**KIRKLEES METROPOLITAN COUNCIL
INVESTMENT & REGENERATION SERVICE**

Reference No:	2023/62/90630/W
Site Address:	53, Greenhead Road, Huddersfield, HD1 4ER
Description:	Erection of two storey extension
Recommending Officer:	Tom Hunt

DECISION – REFUSED

Officer Report

Drawing Title:
Proposed Elevations

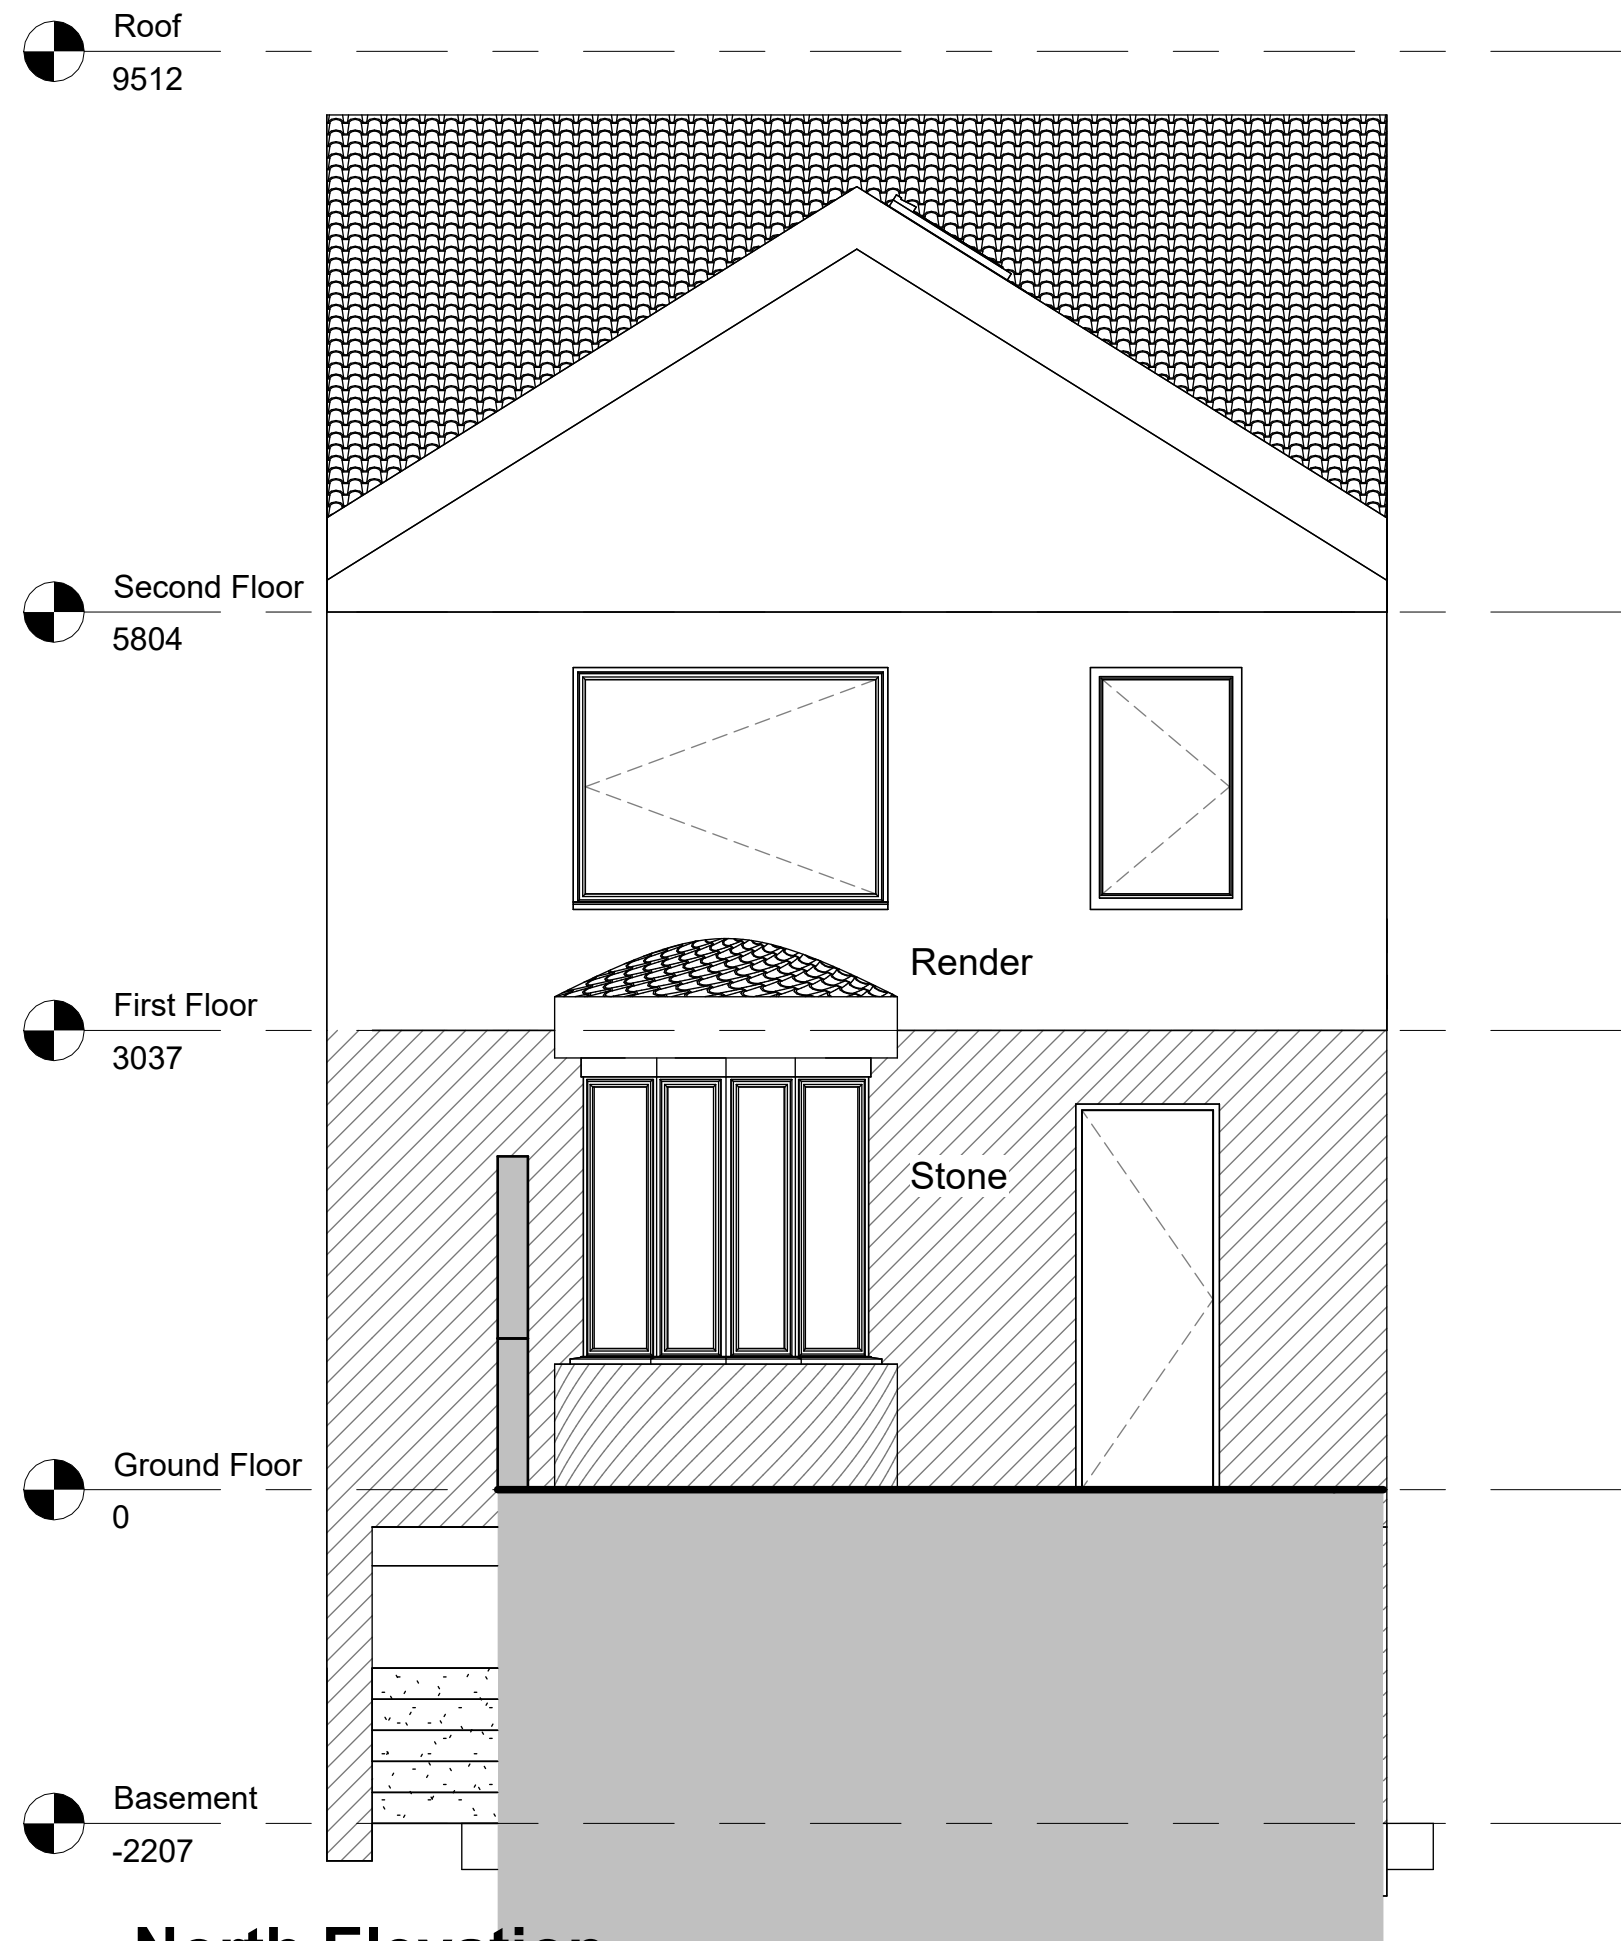
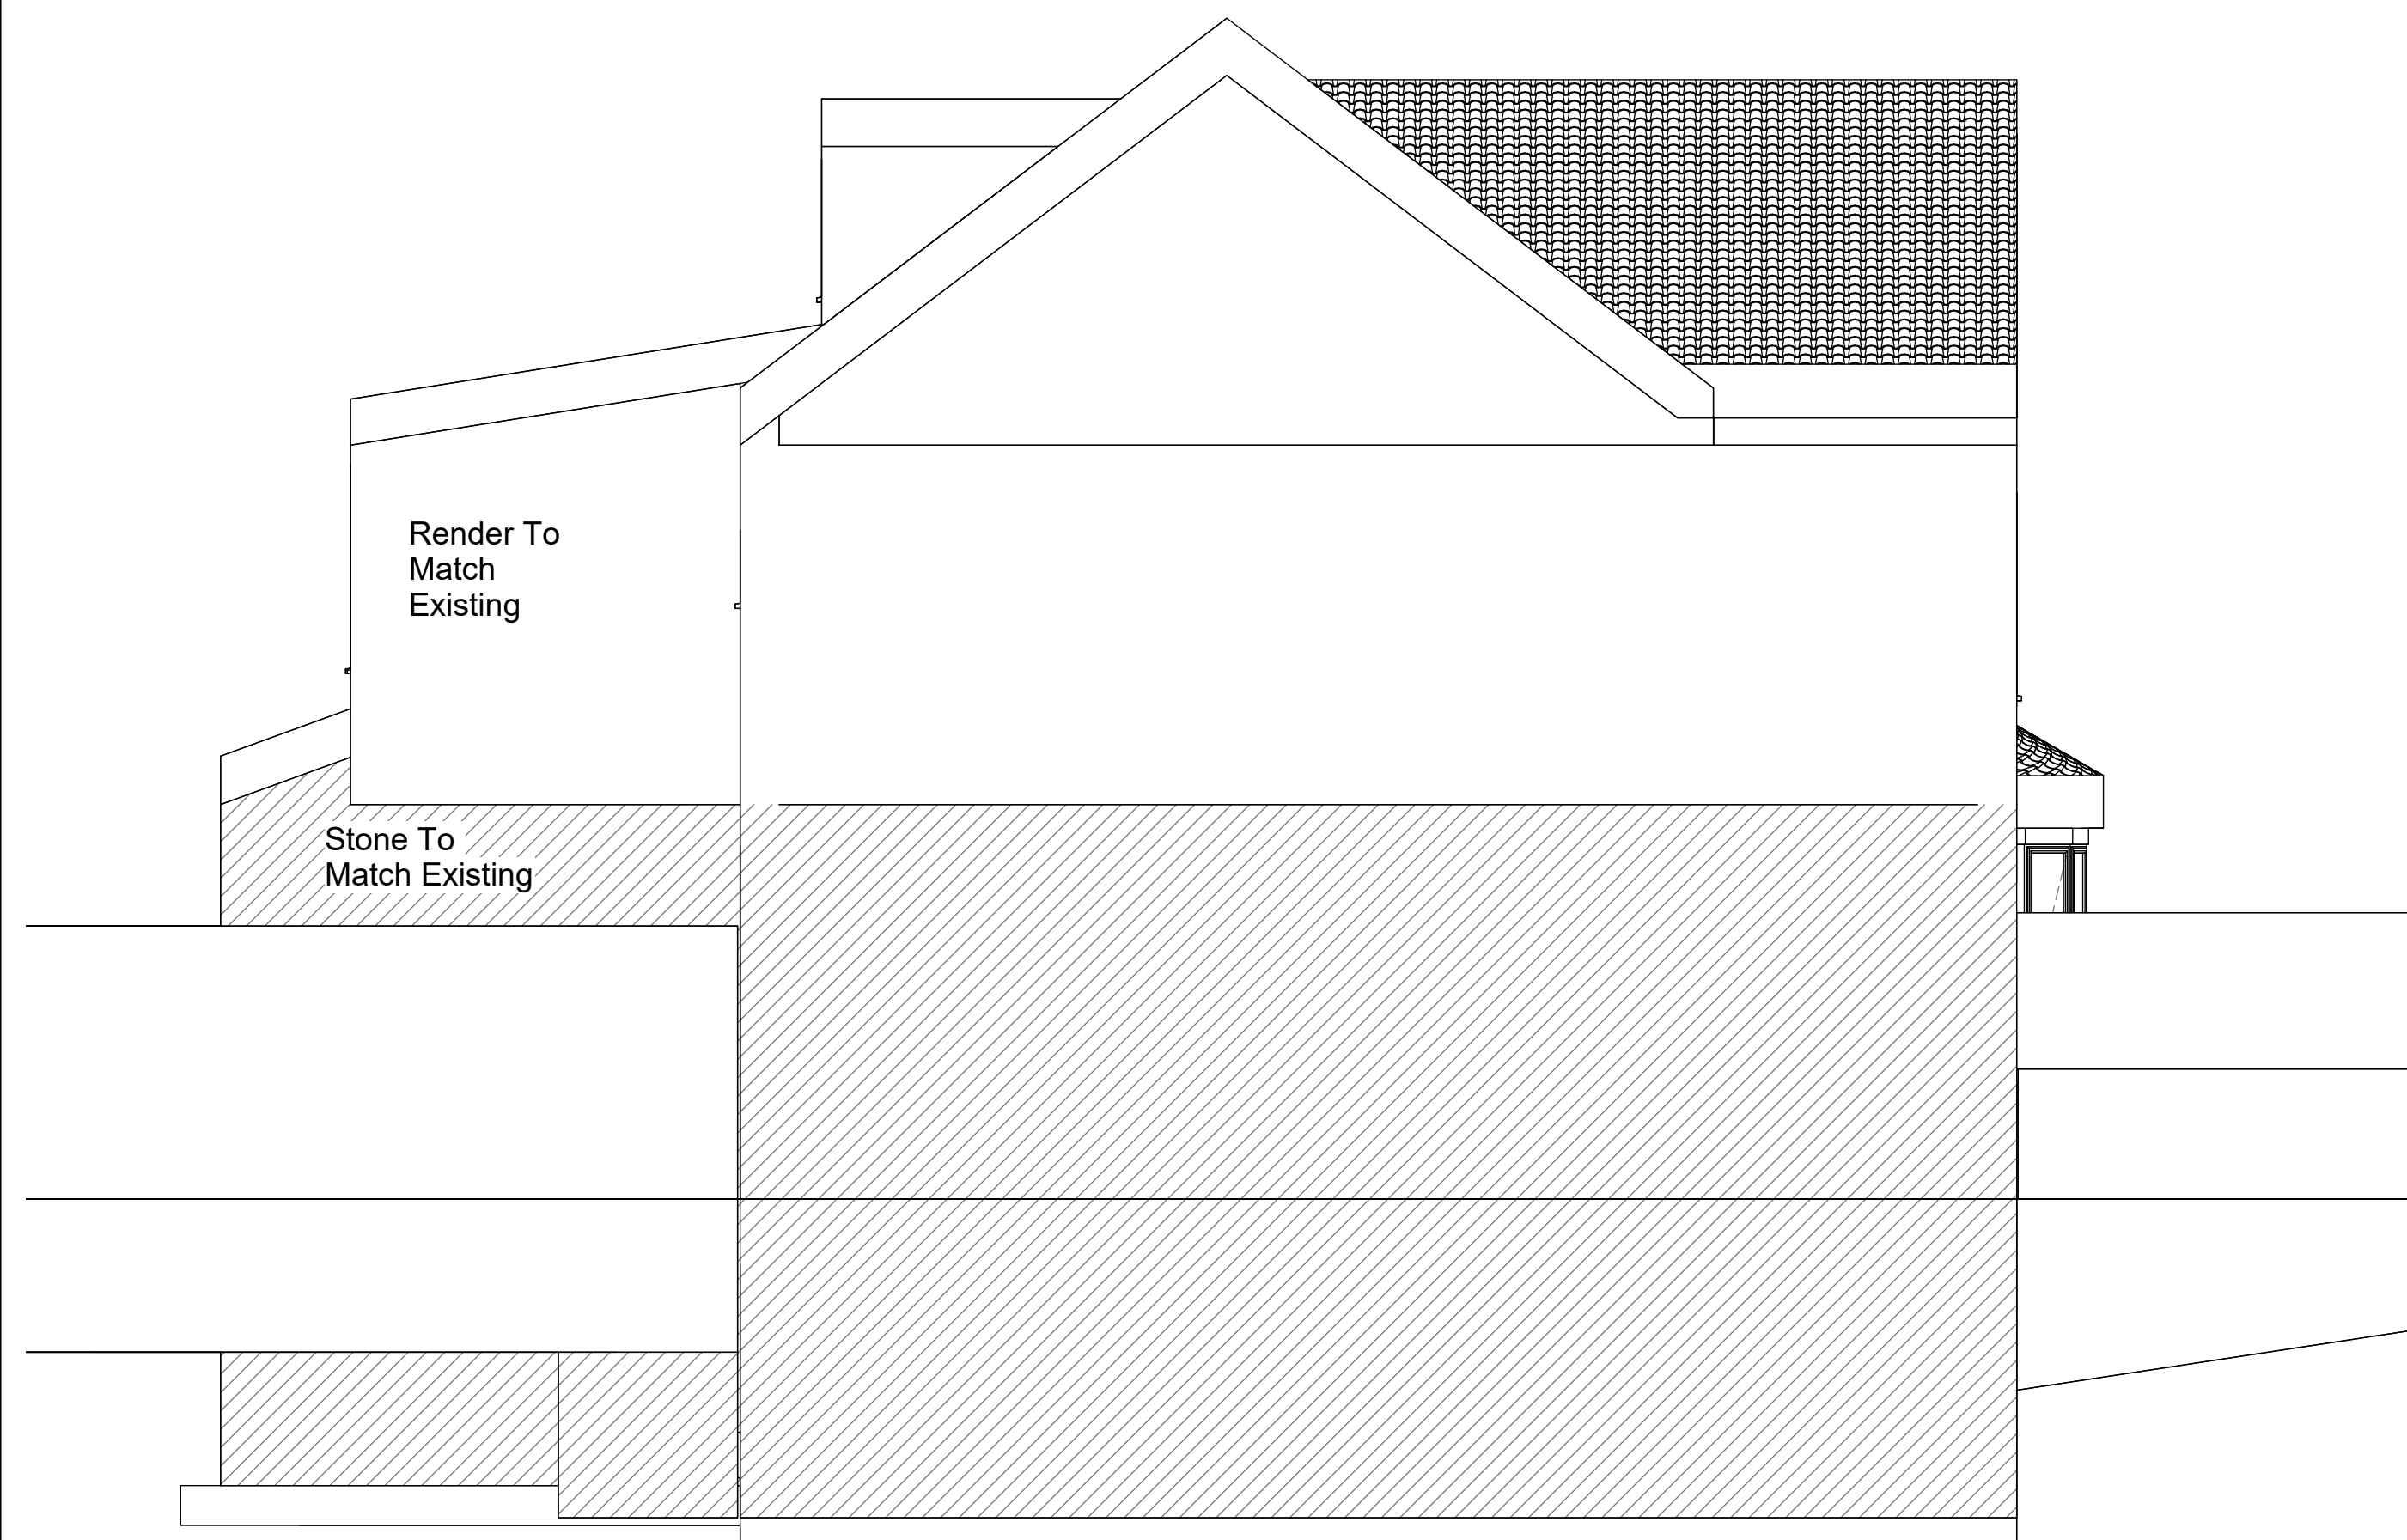
Officer Note: Existing elevation plans do not show the full extent of the gable end front feature and the proposed elevation does not definitively set out the proposed height of the rear raised area with steps.

Considering the impact on visual amenity that had not already been outlined in the above, the proposed dominant design of the tiered two-storey extension would fail to achieve a subservient or sympathetically integrated design to the original host. The proposal would project 4m from the rear at ground and then project 3m at first floor level with a solid understorey base increasing its bulk and massing. It would be closely set onto the southwest shared boundary and set 1.2m back from the northeast boundary with eaves far exceeding a height of 3m failing to offer a 1.5m property gap to boundary increasing its visual dominance and oppressive appearance. Neighbouring houses have not been extended similarly in order to reduce its effects and despite the presence of greenery to the shared boundary, the proposal would not be adequately screened by the greenery of insufficient height.

The tiered design would appear as a cramped and dominant design within its tight plot unduly contrasting with its neighbours with its roofs appearing in pitch and form to be incongruous to the host, its neighbouring properties and others in the locality.

Cumulatively the proposed development would not present a subordinate addition. They would present an undue level of bulk and massing to the host obscuring the original design of the host and to have roofs failing to integrate with the scale and massing of the host's own roof. It would thus fail to respect the original design and character of the host property eroding the character and setting of its locality.
